DECISION DELEGATED TO HEAD OF PLANNING

Application No: H05-0991-24 **Applicant:** Groom Bros Limited
Proposal: Proposed change of use of agricultural building to dwelling
Location: Primrose Farm Maisdyke Lane Fleet
Terminal Date: 17th January 2025

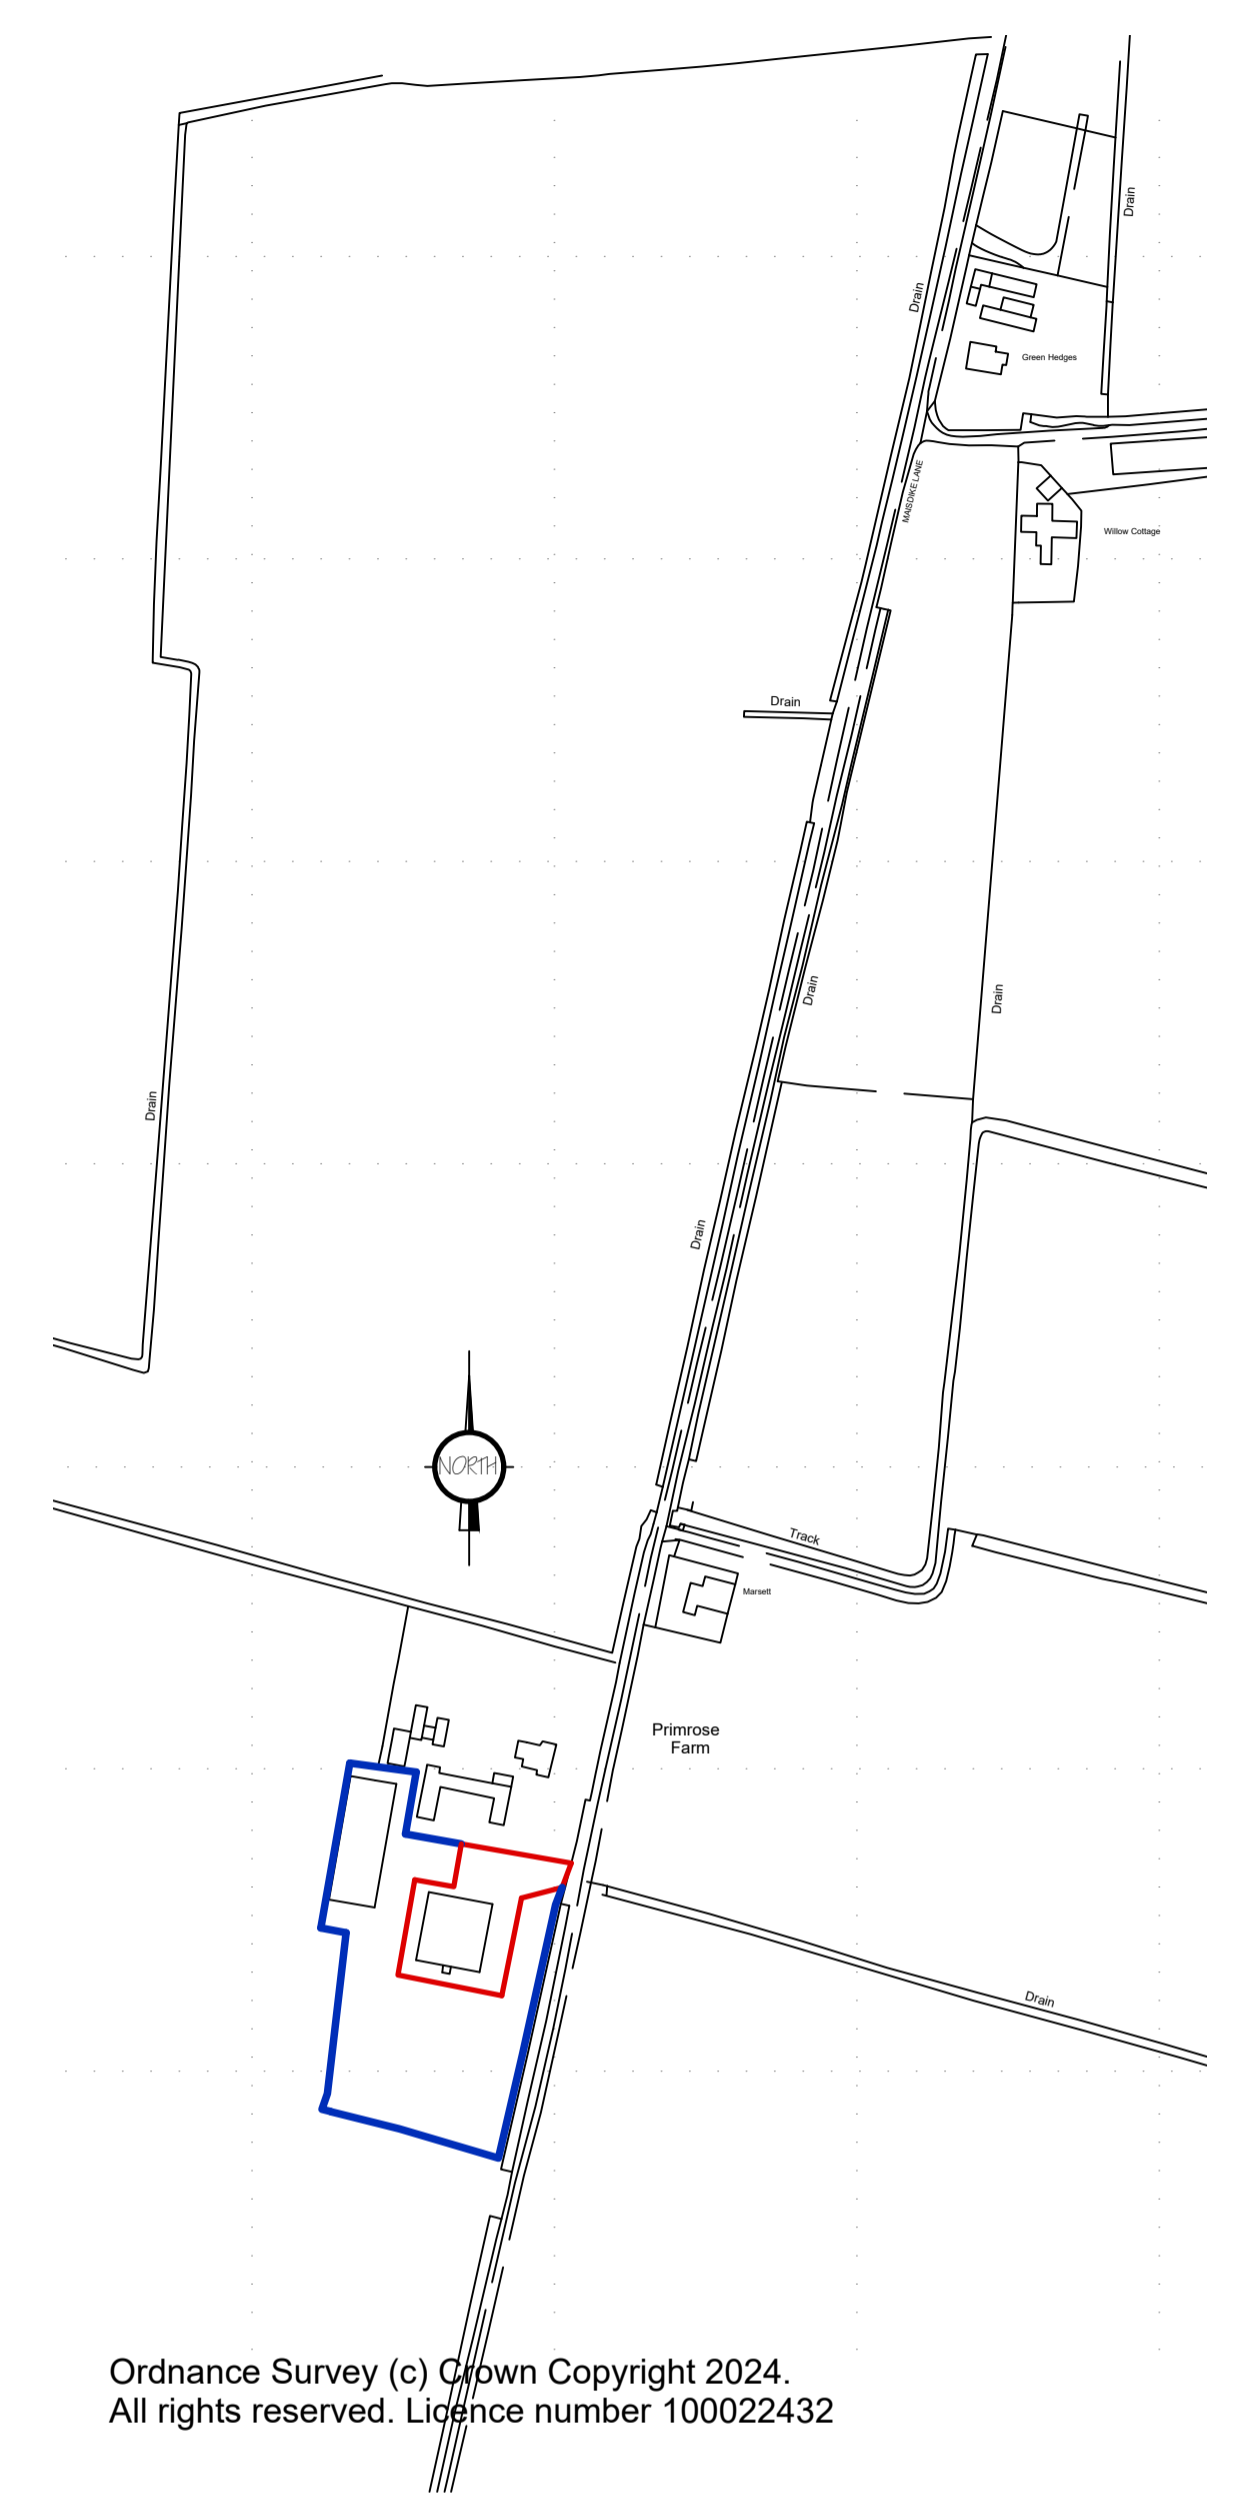
Lincolnshire County Council - Highways and SUDS: A note should be added to the proposed site plan to say the access will be upgraded to Lincolnshire County Council specification.

The proposed access to the site is from Maisdyke Lane to the east of the site. There is an existing access to the site which would continue to be used. Lincolnshire County Council's (LCC's) highways team have not raised any concerns with the proposed visibility splays. The team have however requested that the access is upgraded to LCC's specification. This note is not considered to be necessary as a planning condition is proposed which would require the submission of the proposed surfacing within the site. As such, the access surfacing details will be secured when the condition is discharged. The proposed development is therefore acceptable in terms of highway safety.

Drawing			
BARN ONE FLOOR PLANS - EXISTING & PROPOSED ELEVATIONS - EXISTING & PROPOSED			
Job Ref.		Drawing No.	
429B-24		OIA	
Date		Drawn	
AUGUST 2024		SLB	
Scales

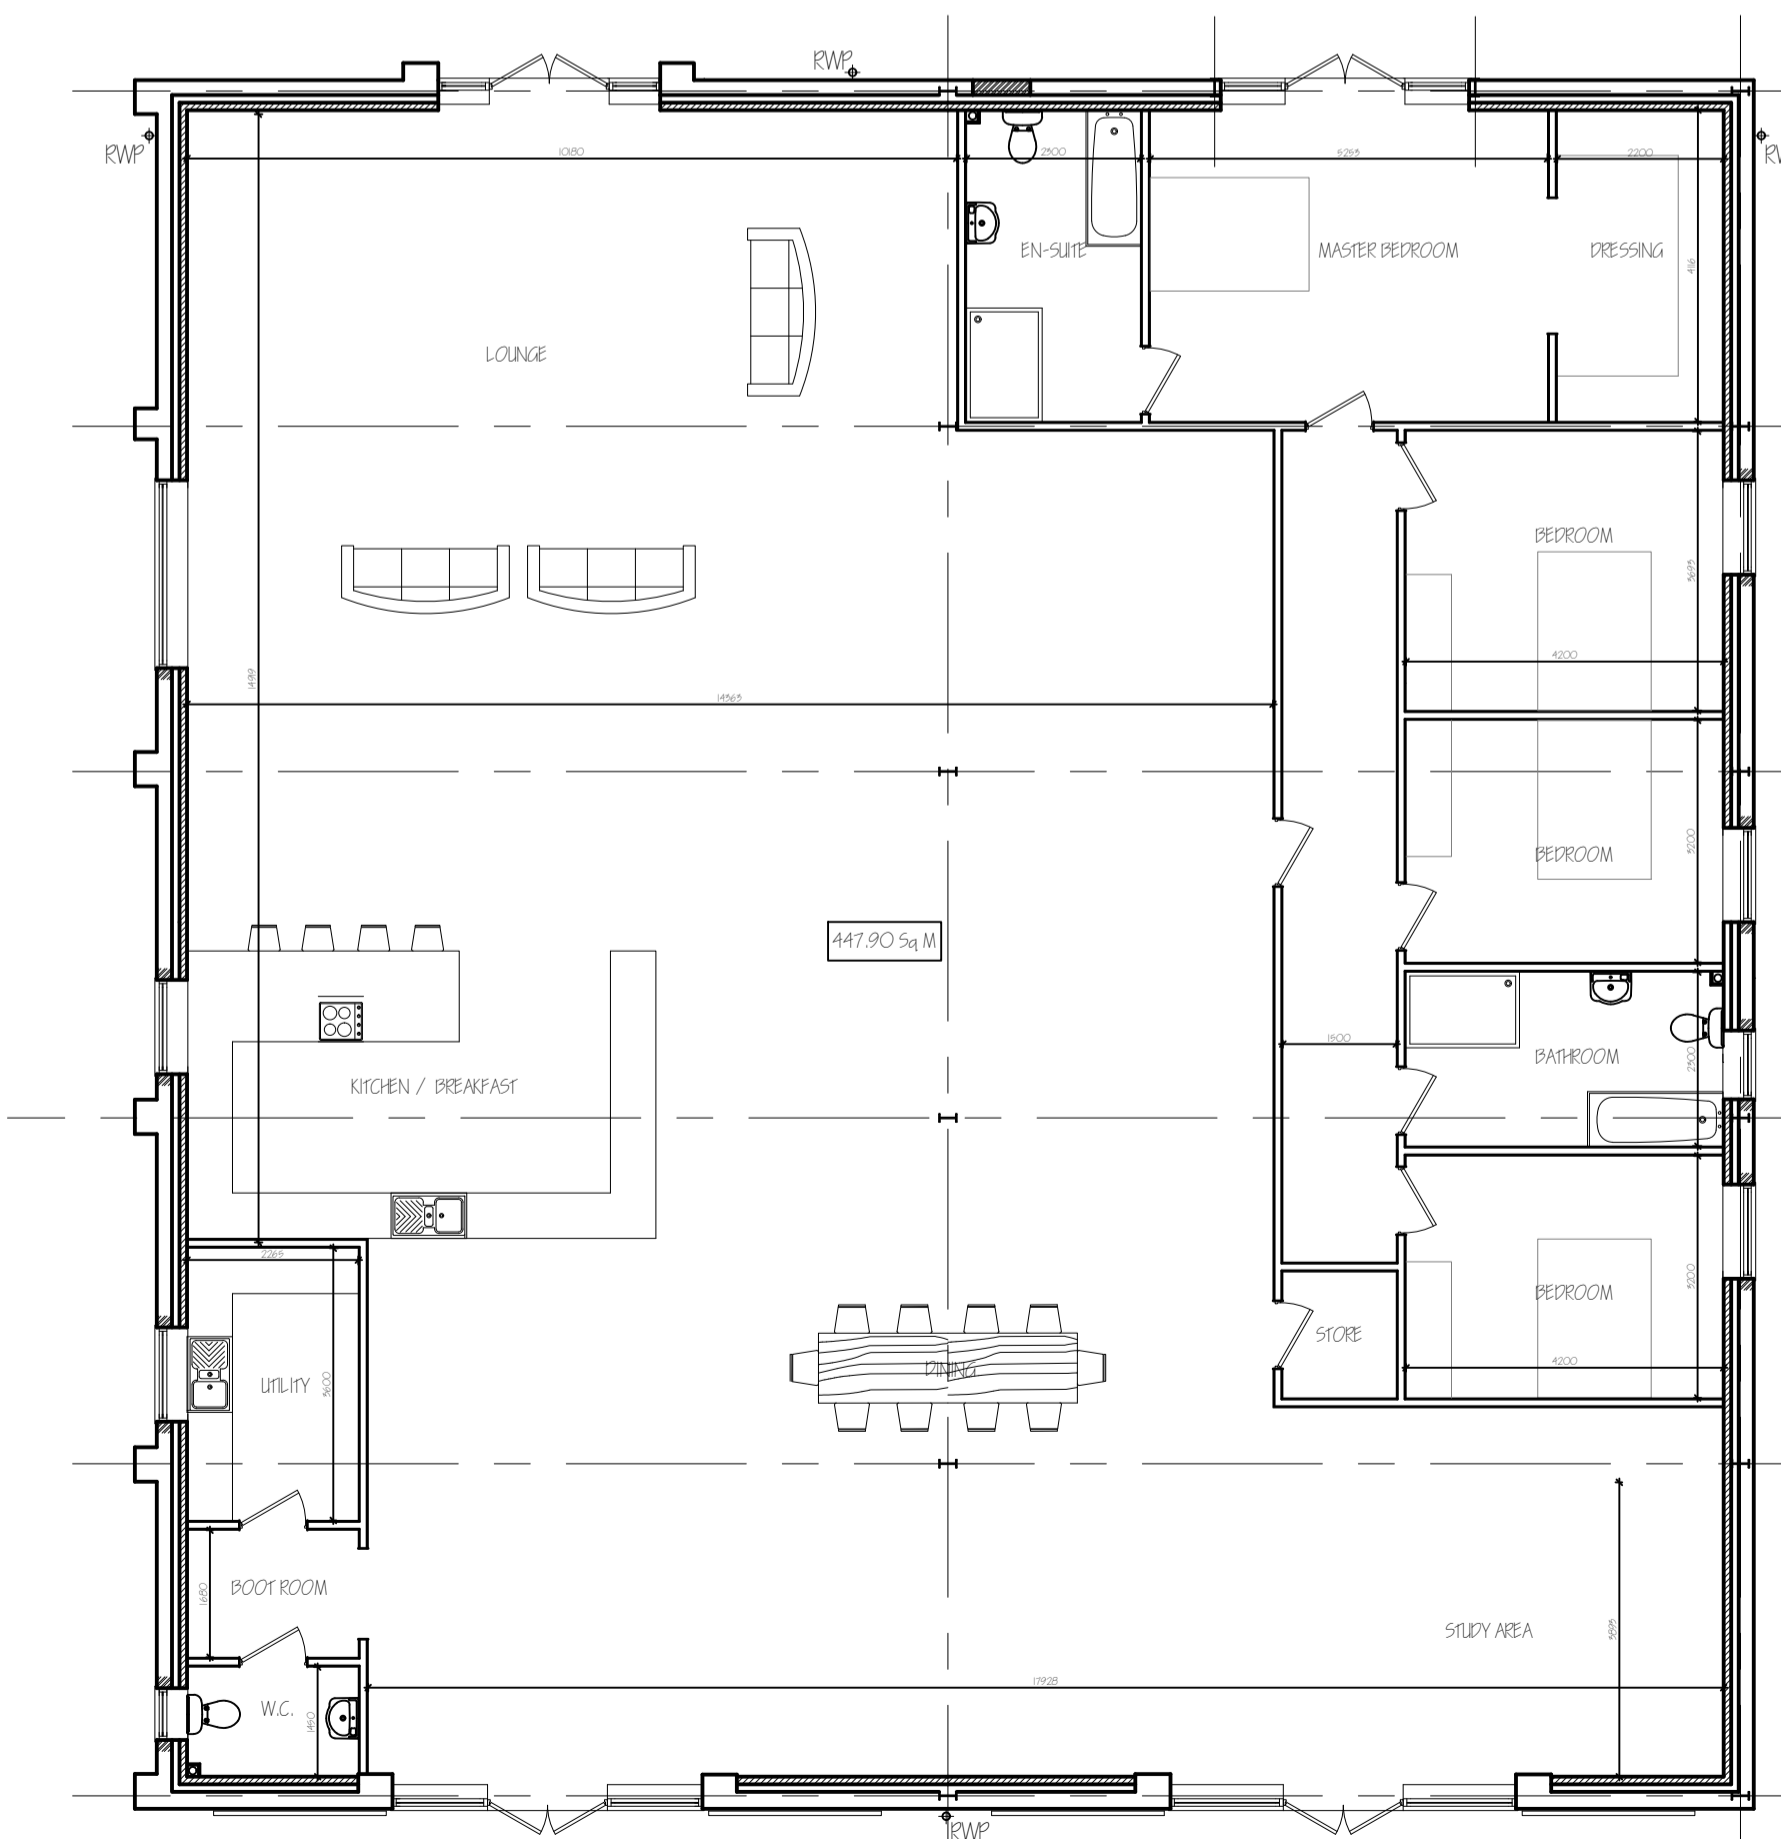
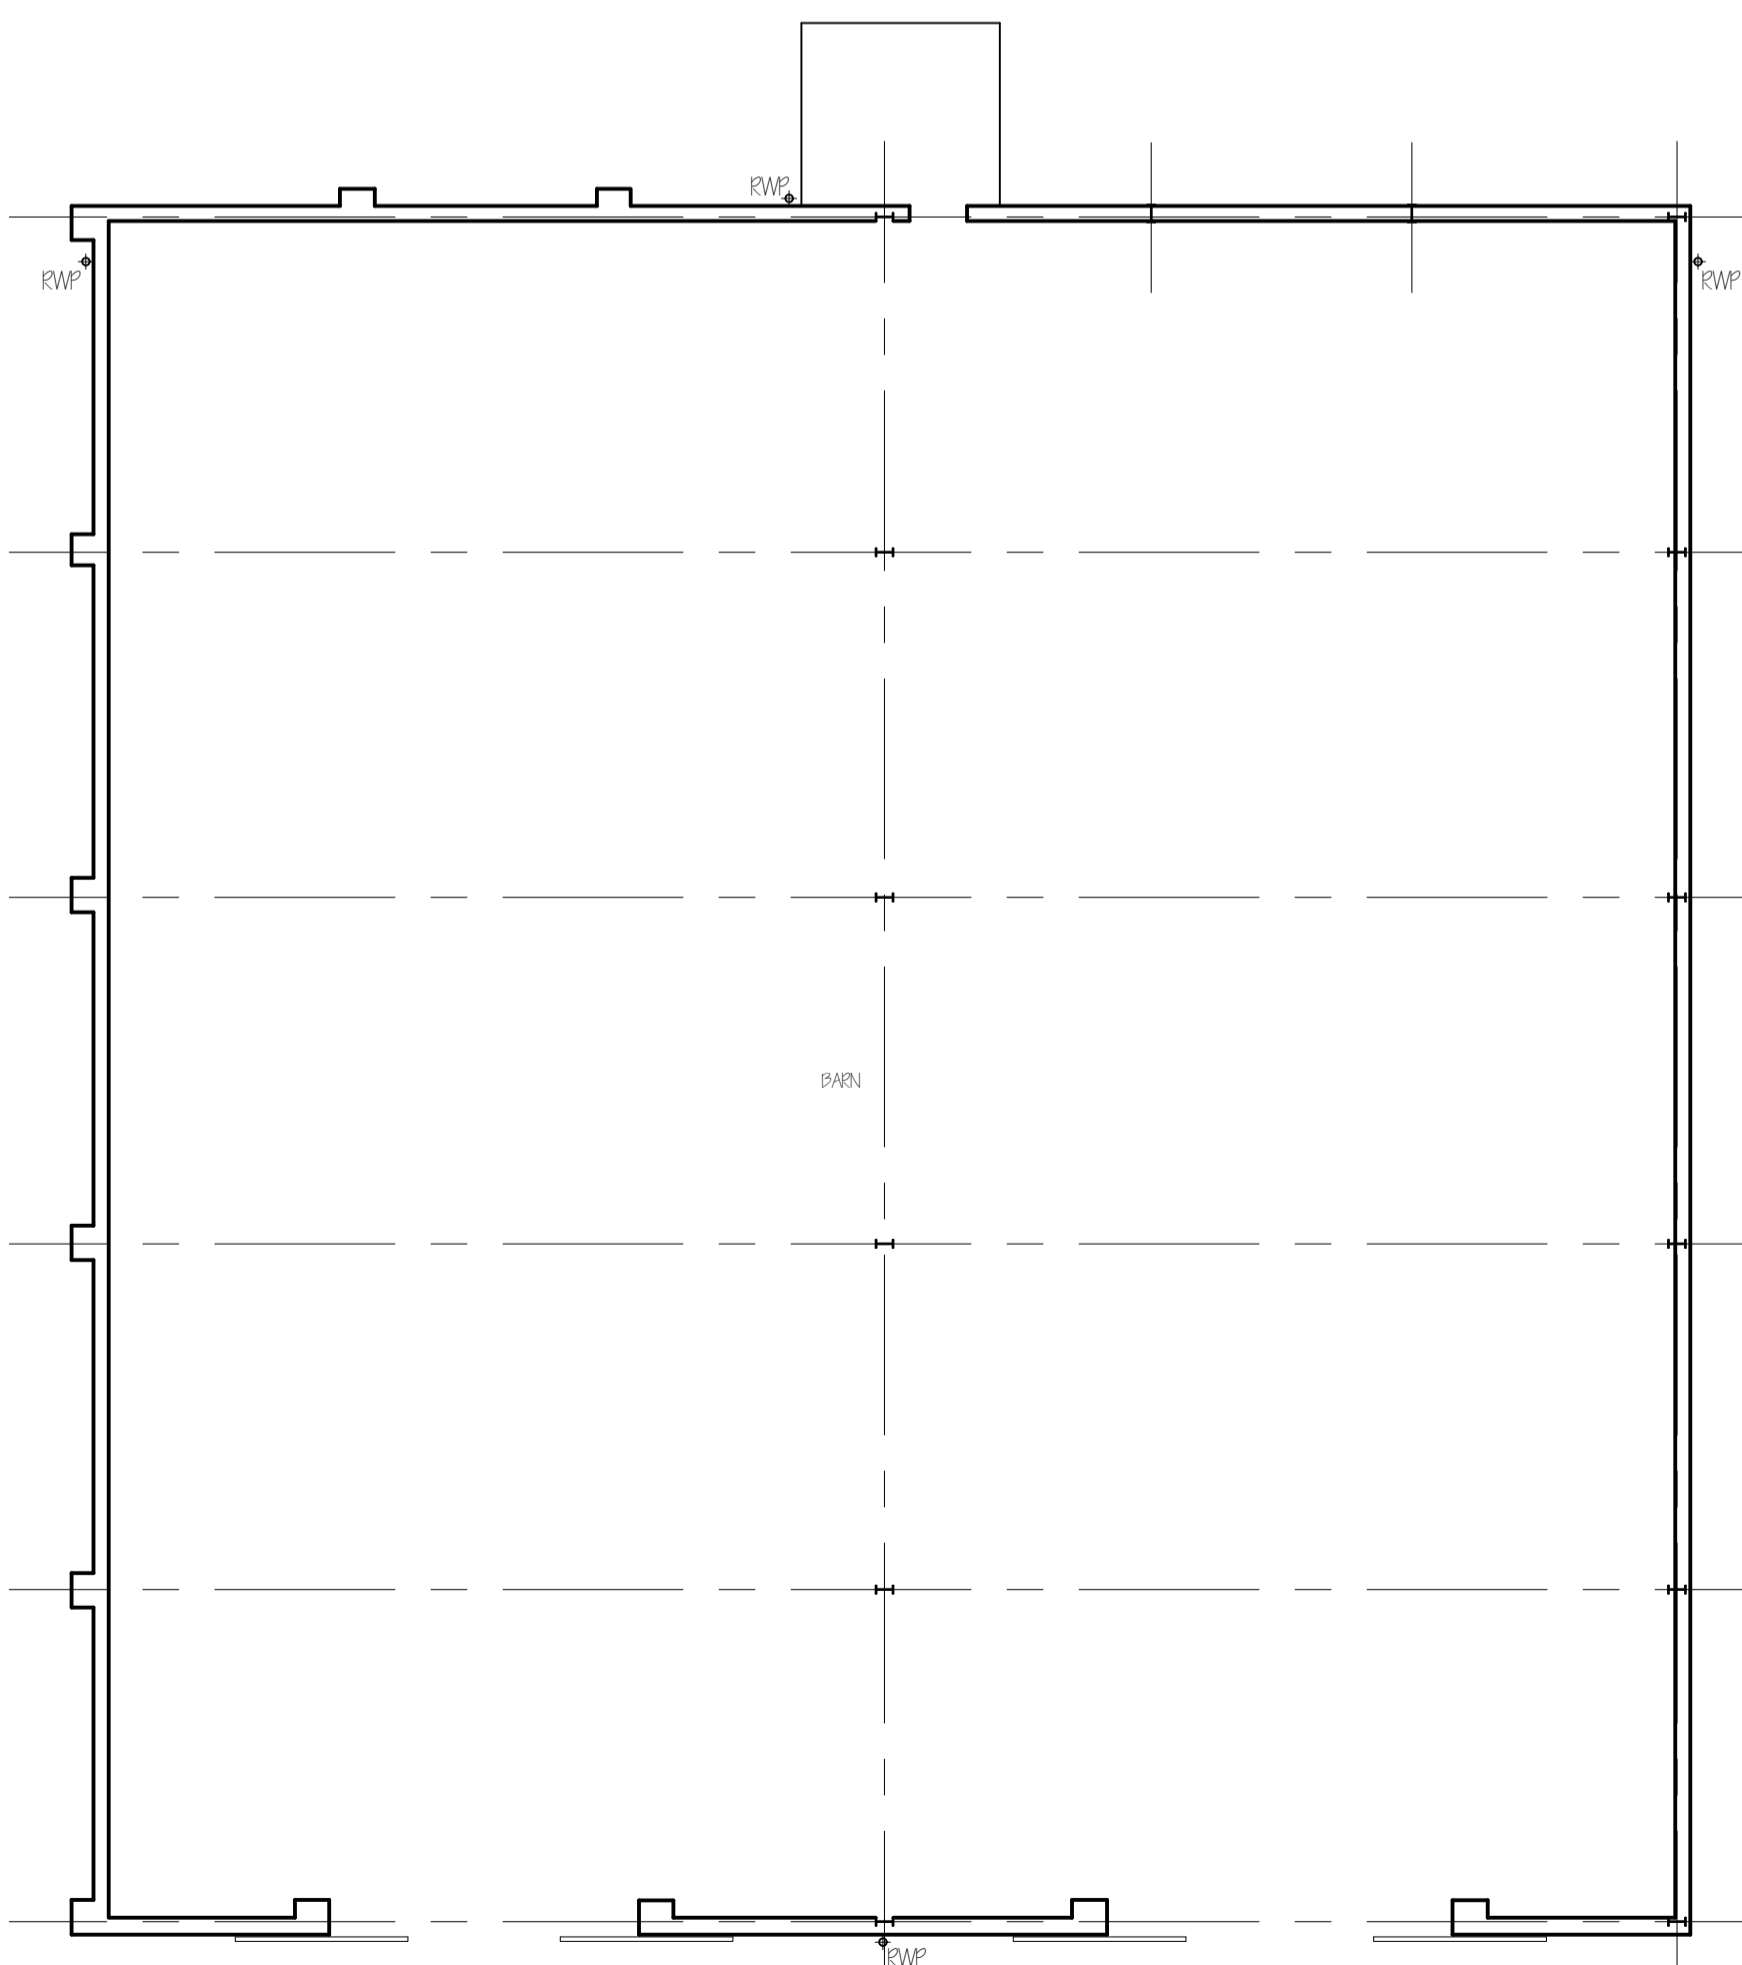
It is proposed to retain the existing facing brickwork and to install larch vertical cladding. A zinc standing seam roof is proposed, grey aluminium windows and doors and black metal rainwater goods. The proposed larch cladding would add a rural element to the appearance and would respect the existing form of the building and its rural setting. The proposed external alterations would therefore not appear overly domestic, or out of character with the surrounding area. It is however considered appropriate to include a condition to secure further details relating to the exact materials to ensure they are of an appropriate quality and appearance. The conversion to residential use is therefore not considered to have an adverse impact on the character and appearance of the rural landscape.

The proposed plans show that all habitable rooms are provided with natural light and ventilation given the location of windows on the building.
